Our Ref: PEF/SD/28854
Your Ref: Y/21/18/DOC

30 April 2018

**Drainage
Land at Kings Close, Yapton**

King Post Retaining Wall Details (Wall on West Boundary)

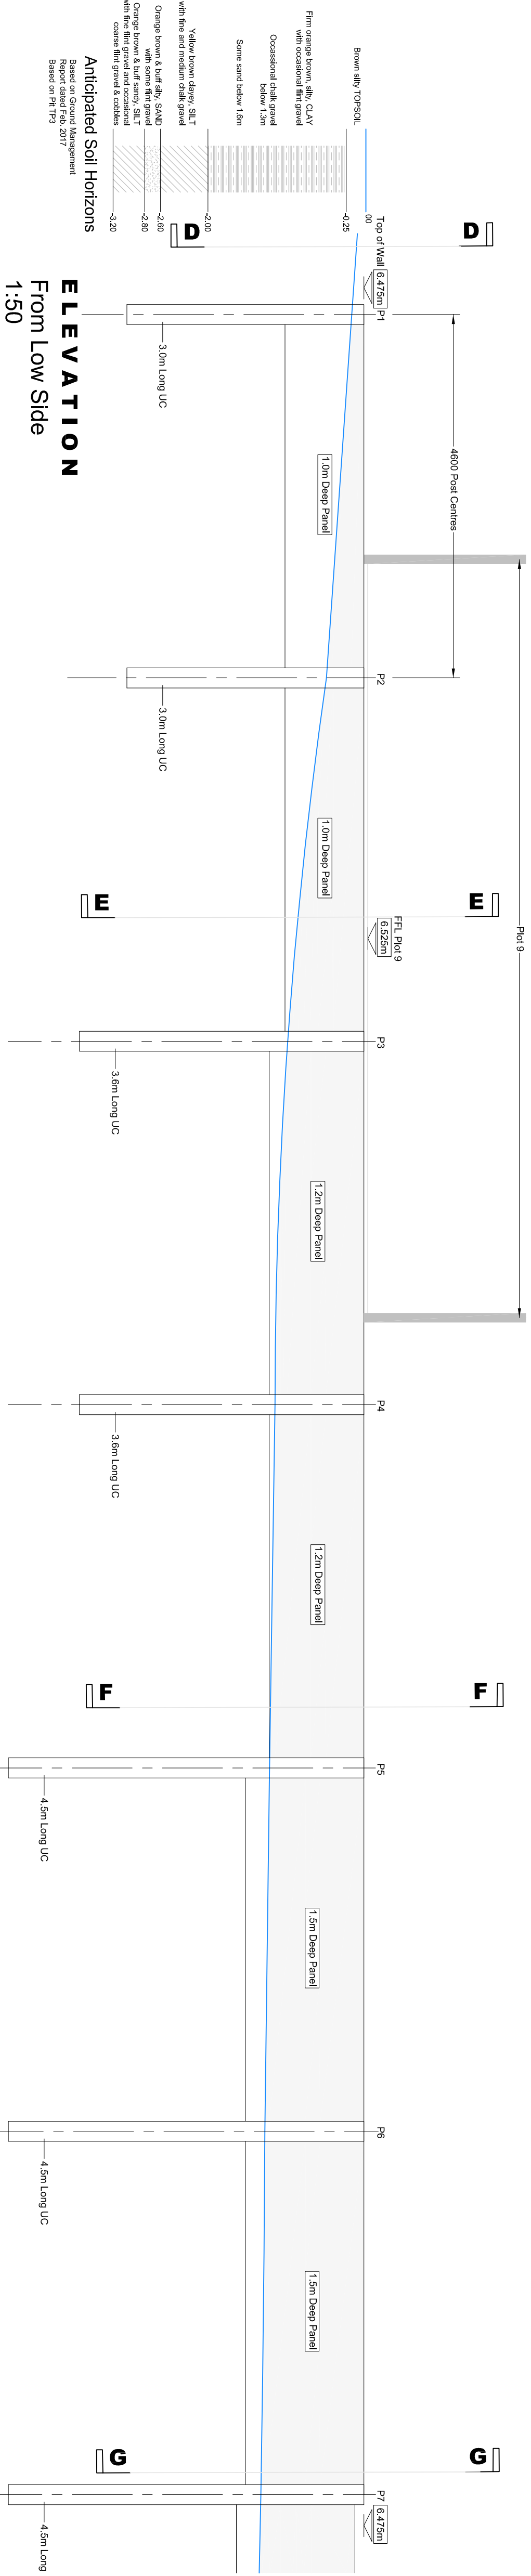
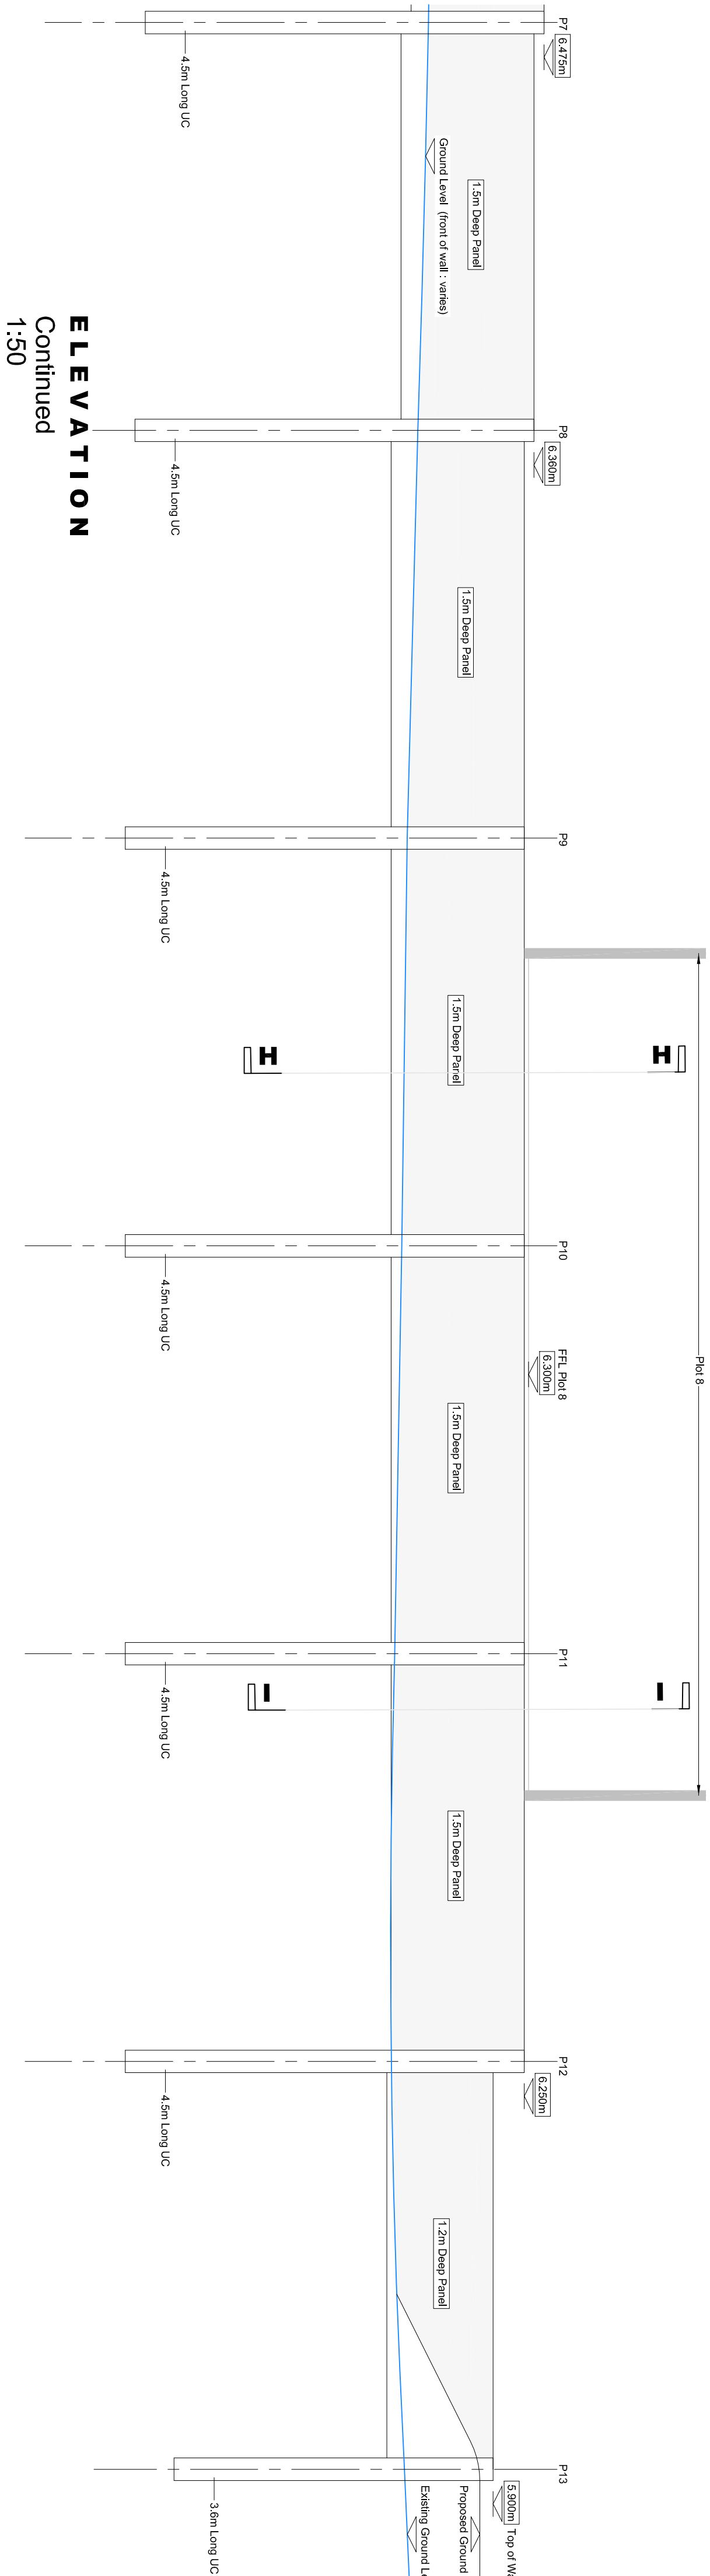
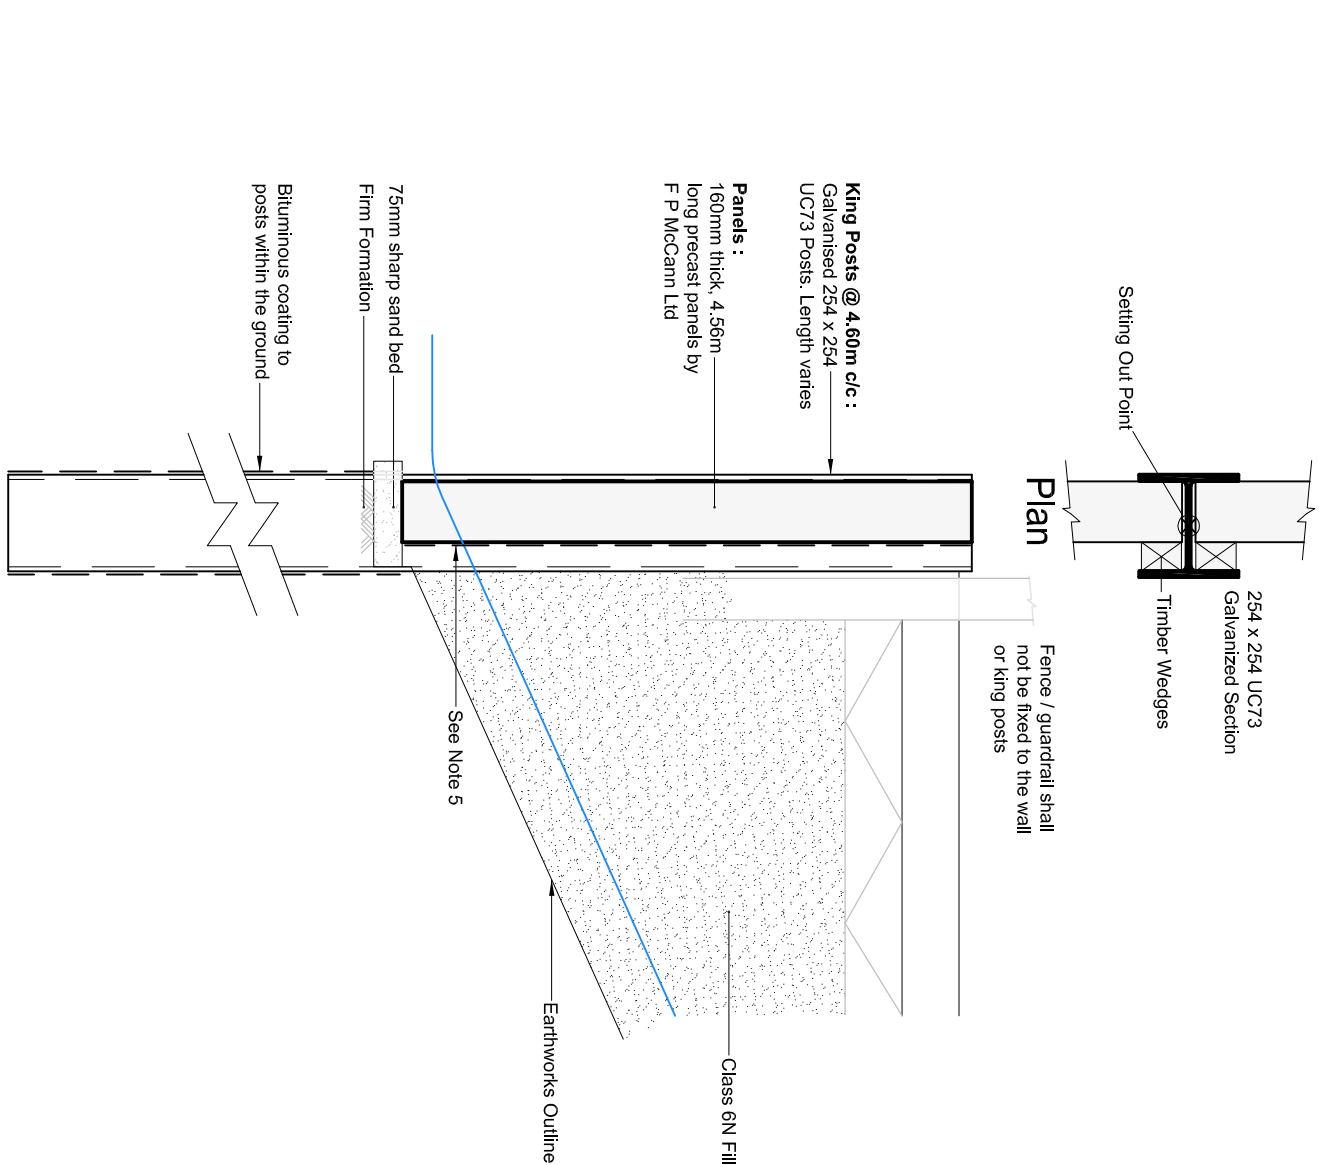
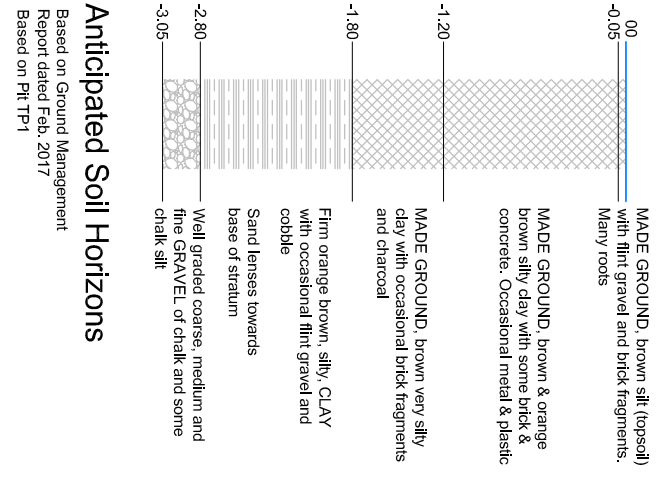
- Soakaway base and cover levels have been added to our drawing No. 28854-101.P4. Base levels represent the invert level of the storage void former.
- Step rungs have been added to our drawing No. STD.01.47A. Manholes Type P2 have not had step rungs detailed to accord with adopted manhole details.
- The depth of the concrete bed at the base of the catchpits has been increased to 225mm.
- Manhole cover types and grades are shown on the schedules and standard drawings. Cover grades A15, B125, C250 and D400 imply compliance with BS EN124.
- Our marked-up drawing shows flood exceedance flow routes.
- Drawings 106.P2 and 107.P1 show sections through the proposed king post retaining wall.
